CITY OF ALBUQUERQUE

**Planning Department
Transportation Development Services Section**

Re: Certification Submittal for Final Building Certificate of Occupancy for
Office Warehouse, [L-20 / D064]
601 General Hodges SE
Architect's Stamp Dated 01/07/09

**RE: 'OFFICE WAREHOUSE' LOCATED AT 601 GENERAL
HODGES S. E., ALBUQUERQUE, N. M.**

MAINTENANCE BY OWNER

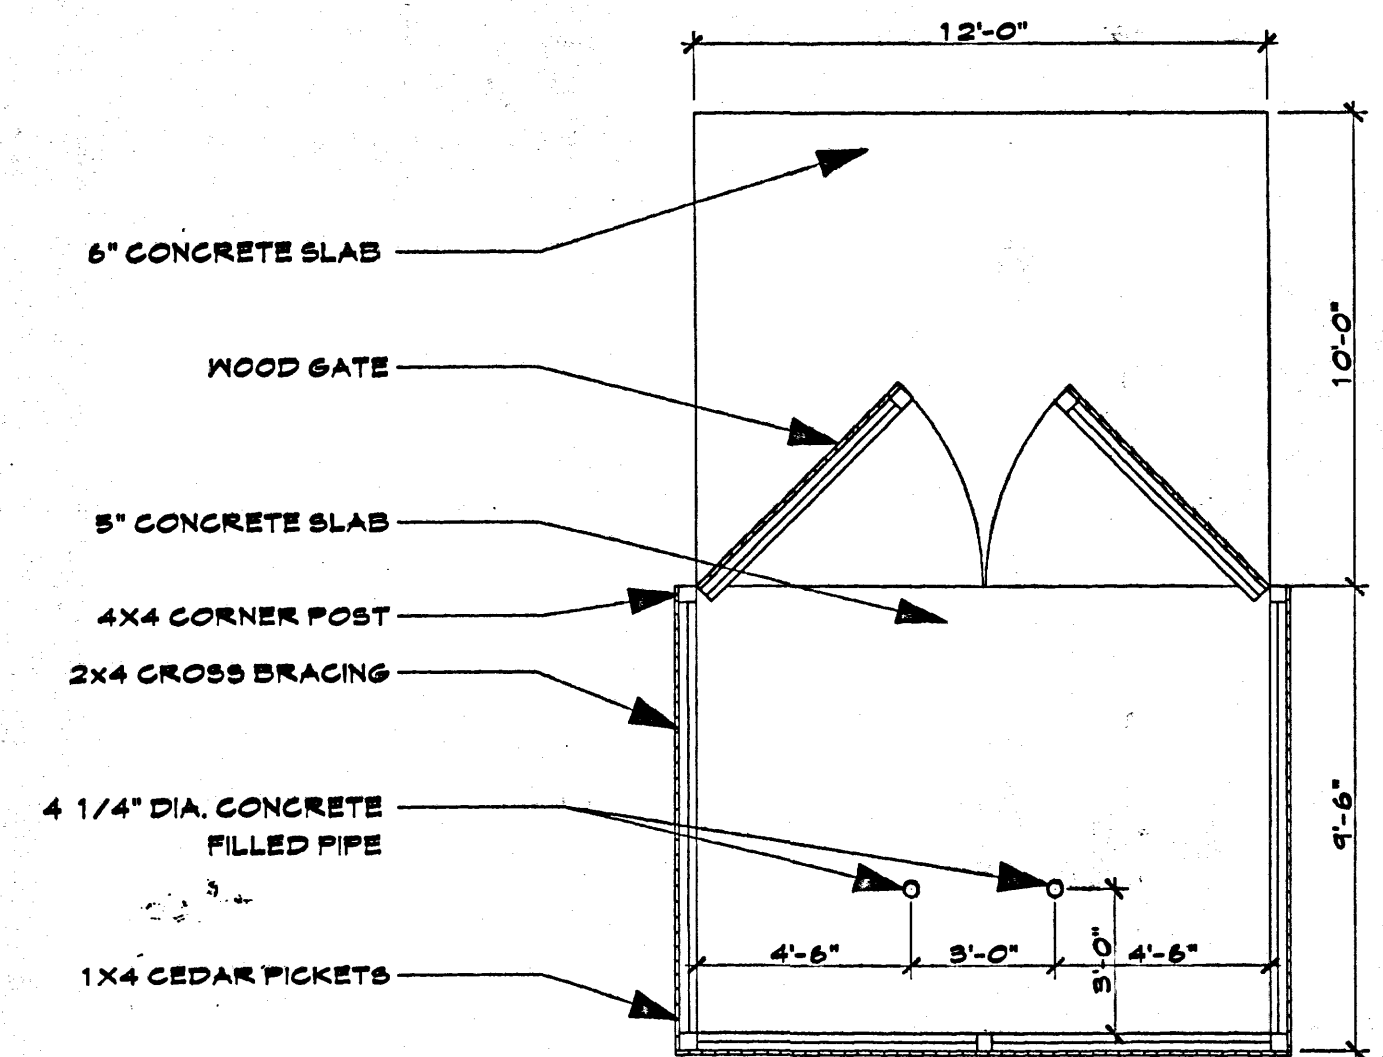
1. Call out the distance between the ramp and the edge of sidewalk to the east
of the handicapped ramp. This distance should be a minimum of 3', or
consider a different type of ramp.
2. CoA Standard 2425 does not have wheelchair ramps. Please amend your
plan accordingly.
3. Please stamp, sign, and date the plans.

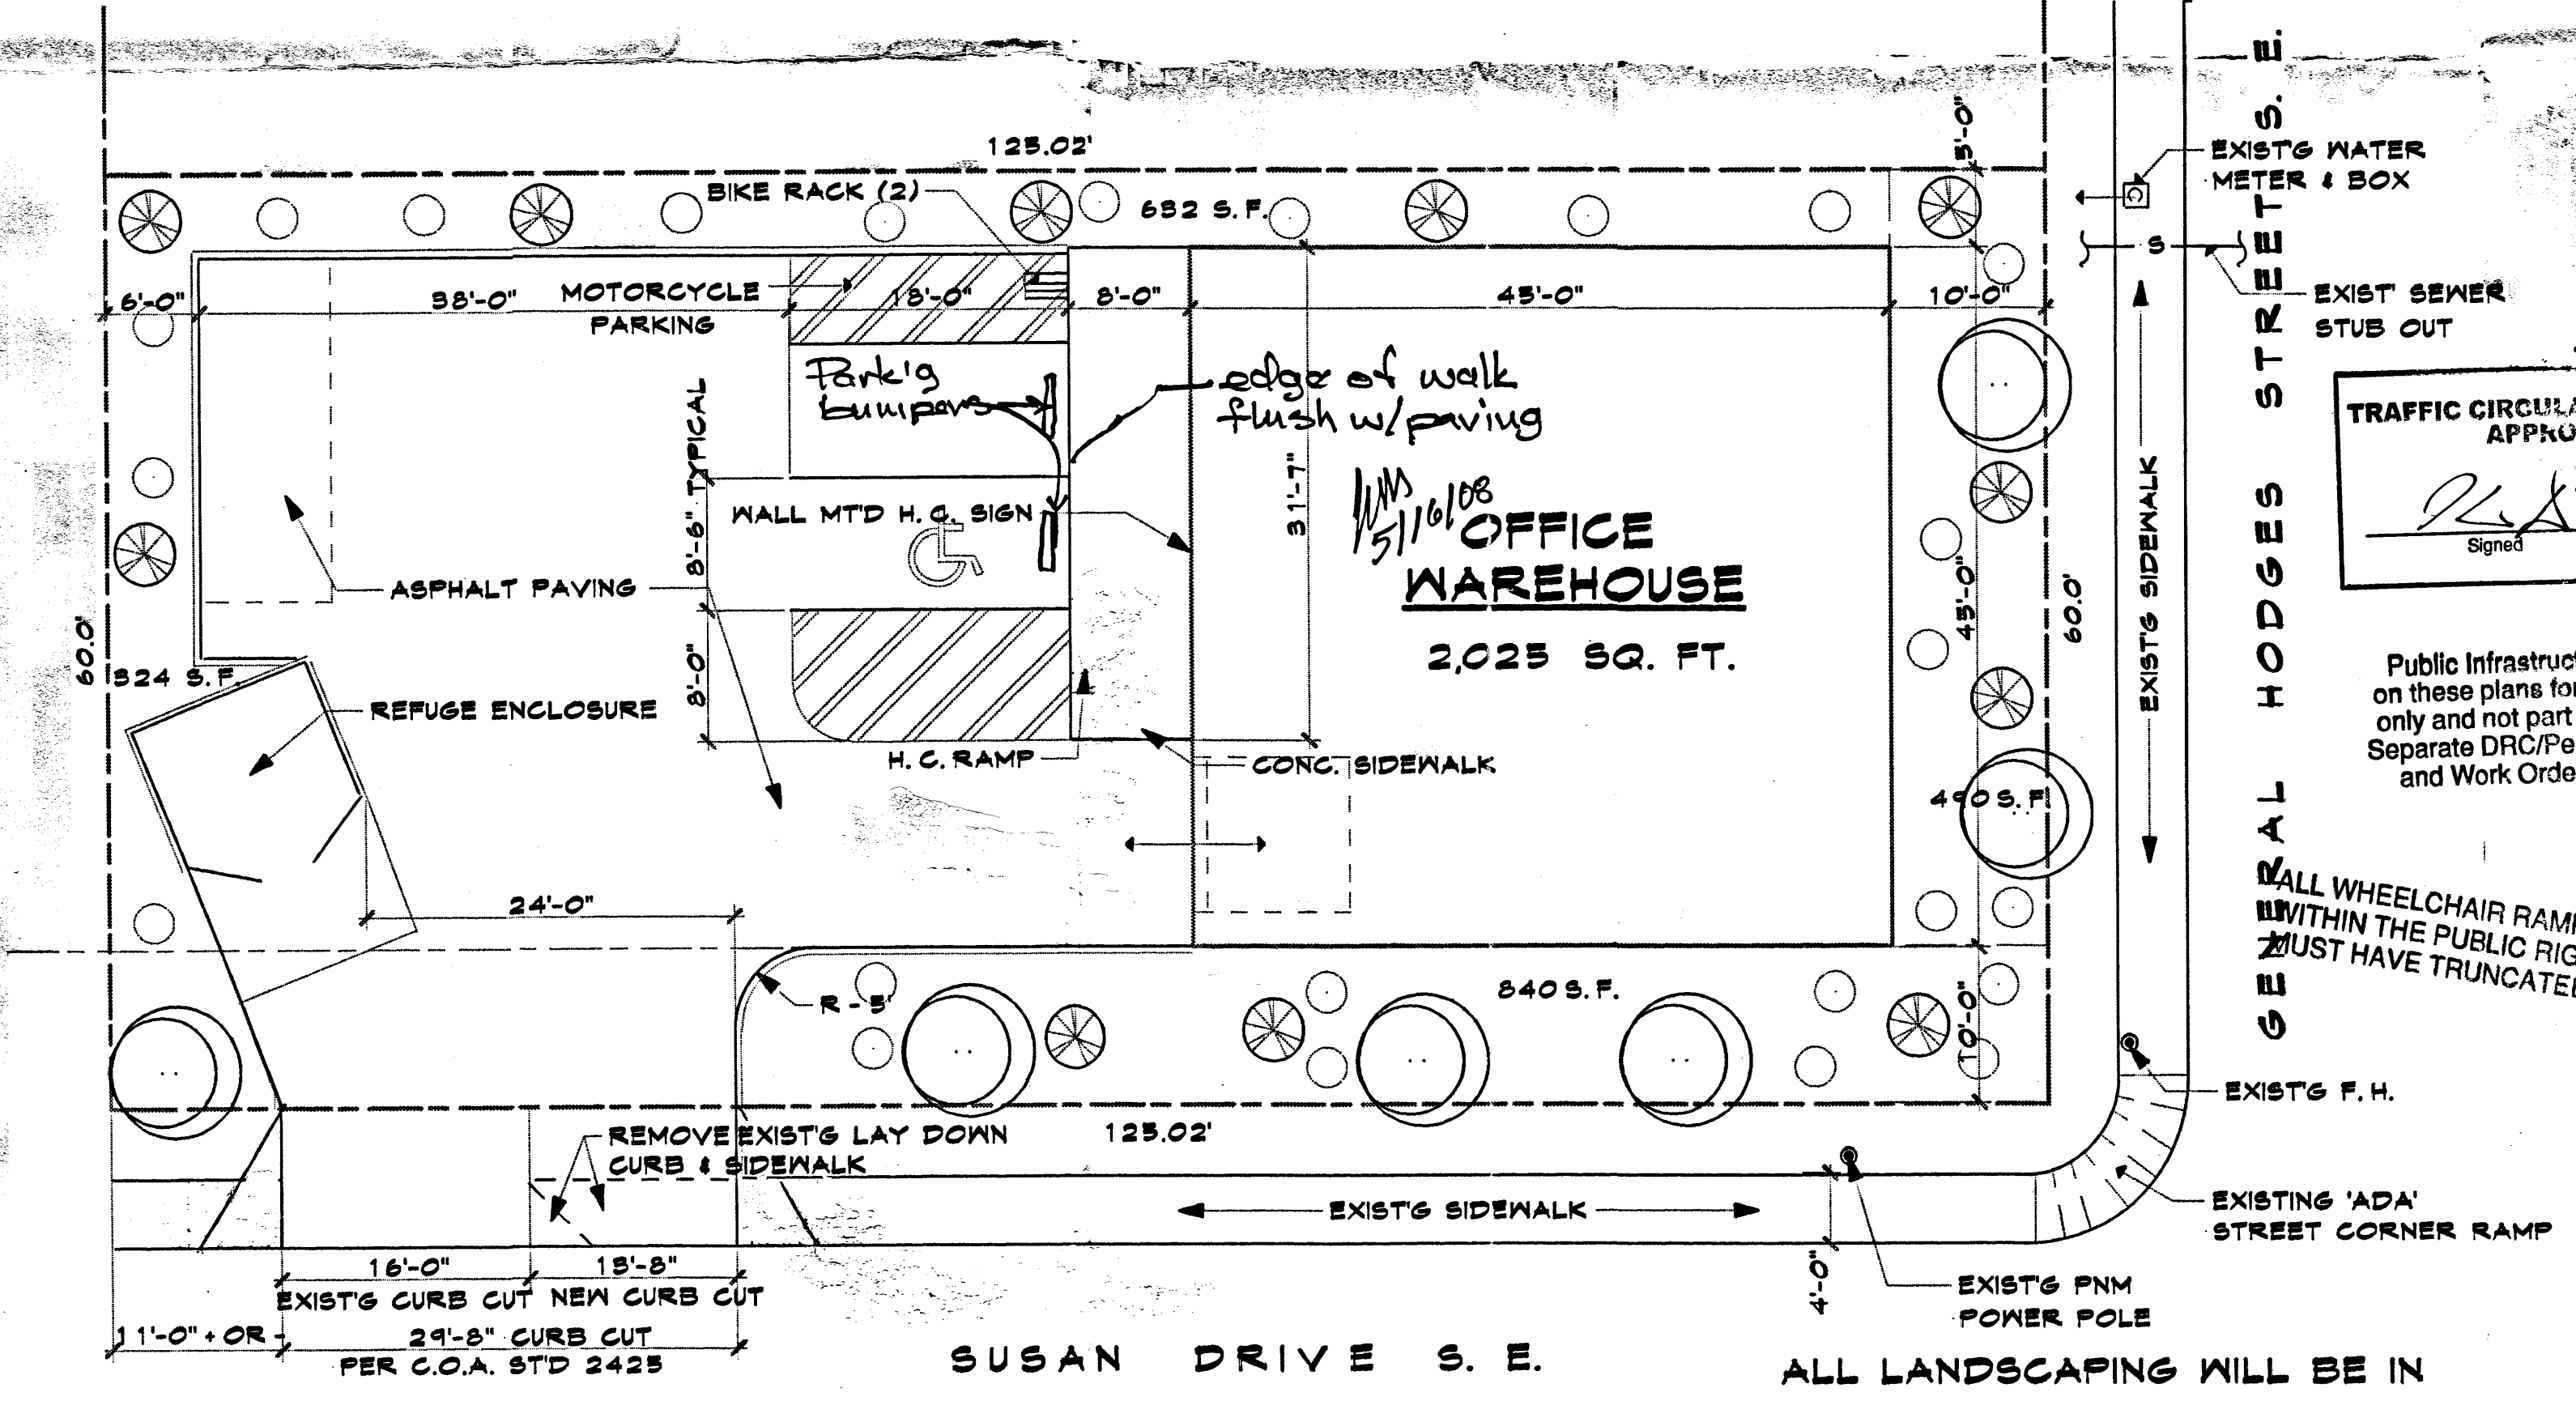
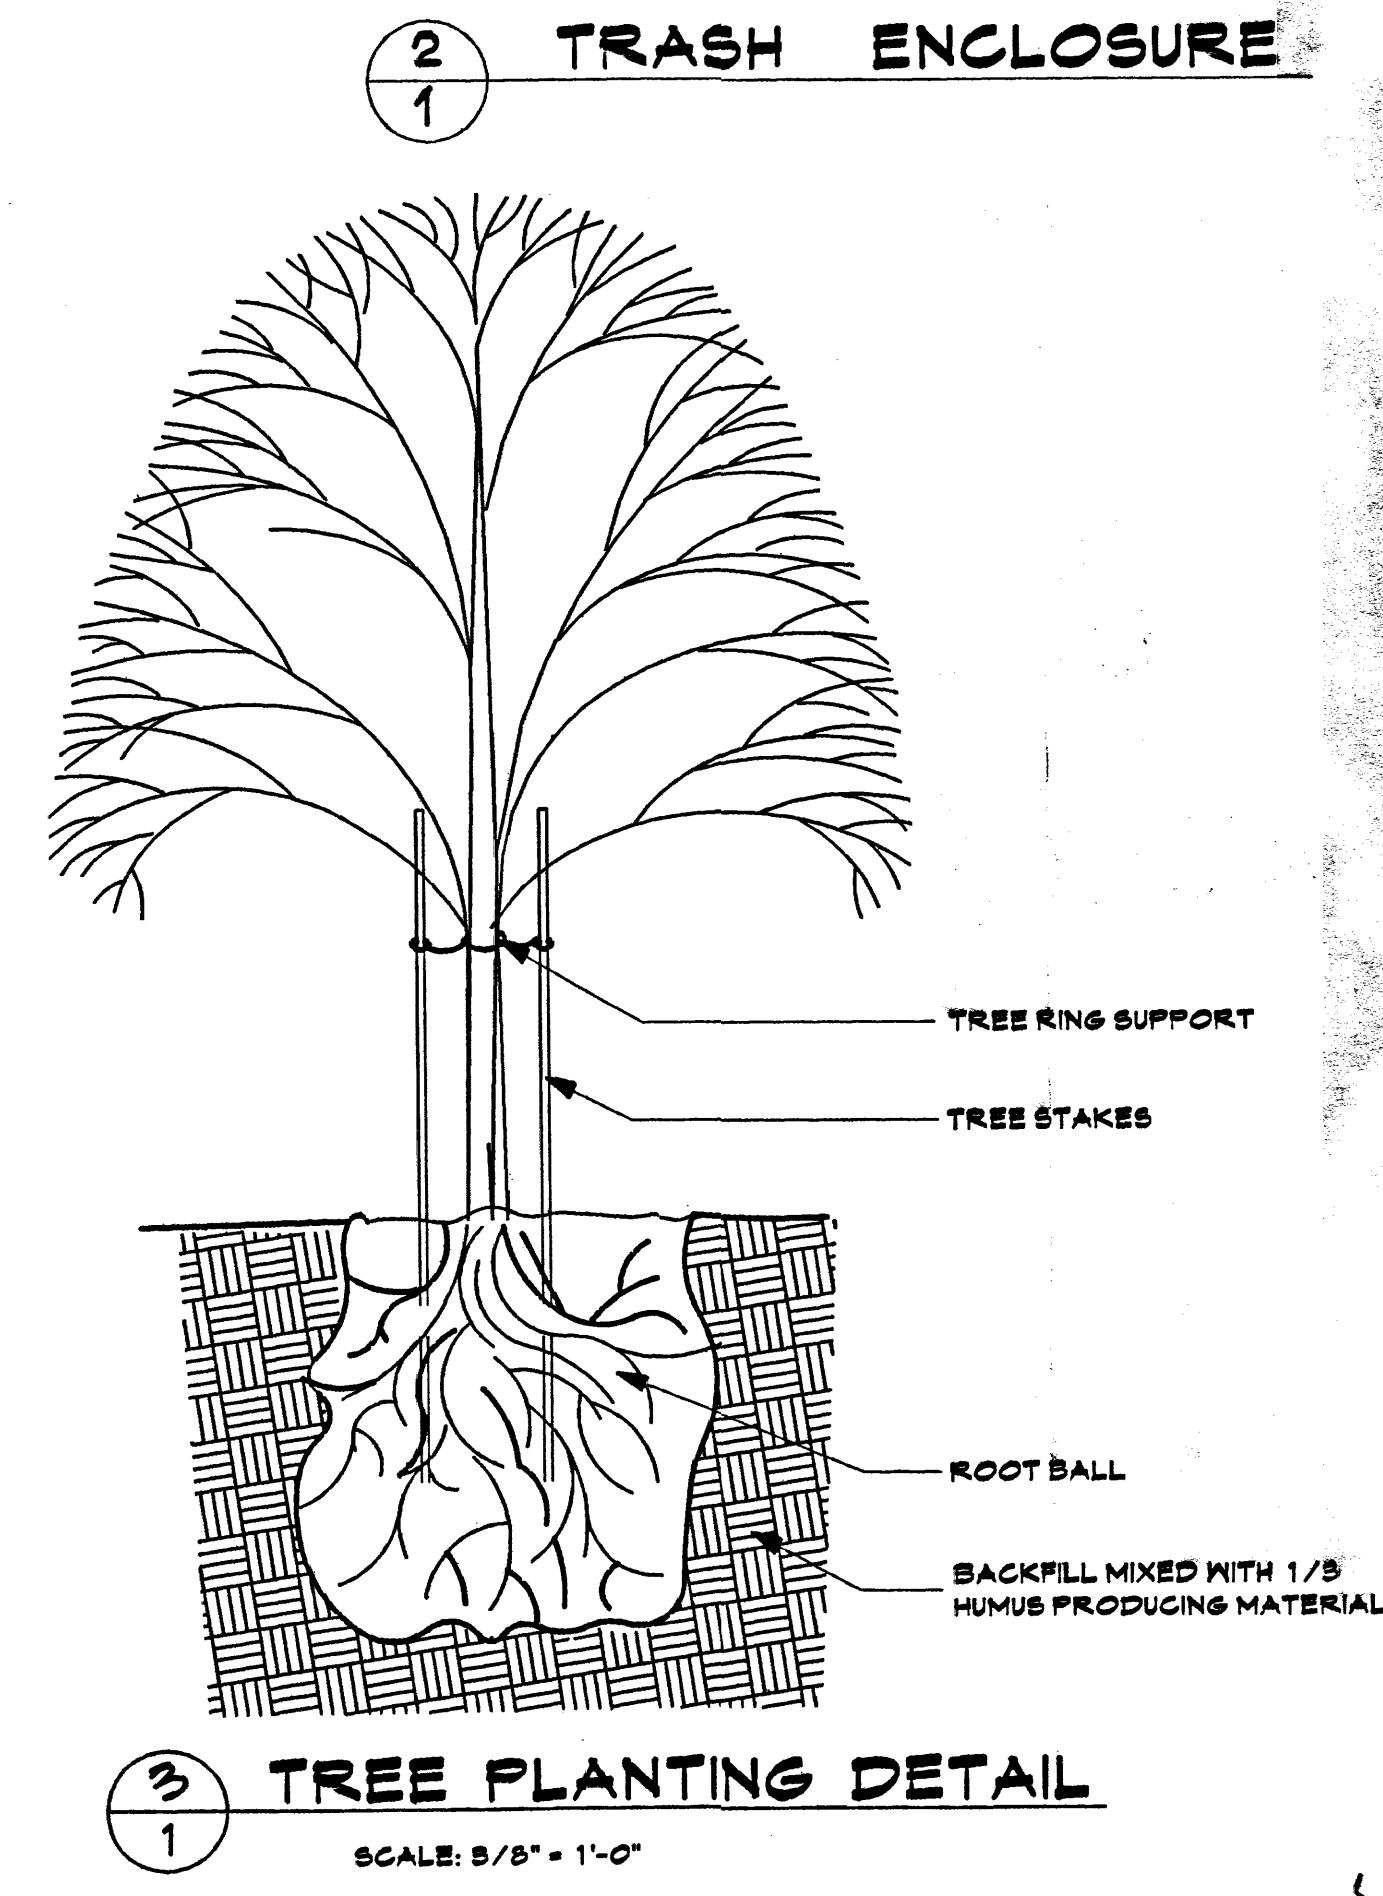
- ✓1. Call out the width of the existing sidewalk.
- ✓2. Show the heavy vehicle path. How will loading occur?
- ✓3. Dimension the van access aisle.
- ✓4. Do the ramps at Susan and General Hodges meet current ADA criteria; if not they will need to be replaced.
- ✓5. Include a vicinity map on the plans.
- 6. Call out the distance between the ramp and the edge of sidewalk ^{to the east} for the handicapped detail. This distance should be a minimum of 3', or consider a different type of ramp.

→ CoA Std 2425 does not have wheel chair ramps. Please amend your plan accordingly.
